RE YOUR REF. R/253/20/HH

33 KNIGHTSCRAFT AVE.

I wish to place an objection to the above planning application

PROPOSED PLAN 1:100

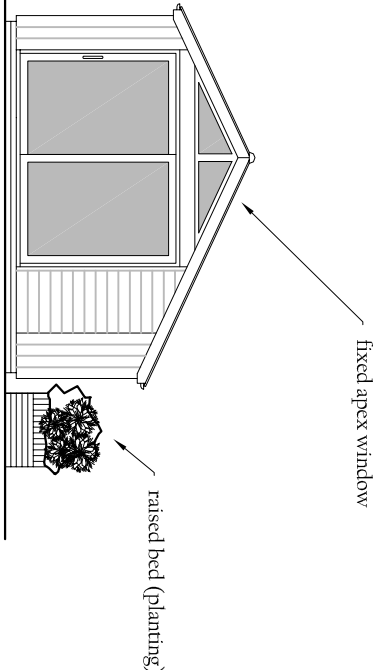
- 1) I live next door (No 35). The bungalows would run the length of their garden close to their fence (on my side). It will take my light.
- 2) I am concerned there would be increased footfall - (tradesmen etc) down the sideways.
- 3) There is a covenant covering the whole Cudlow estate which states one dwelling per site.
- 4) I consider it will de-value my property and create more than the usual and acceptable noise in the garden.

- 6) I believe the close proximity of proposed

lungalows to St. Bridget's Cheshire home
may well affect their light in what I
understand are bedrooms.
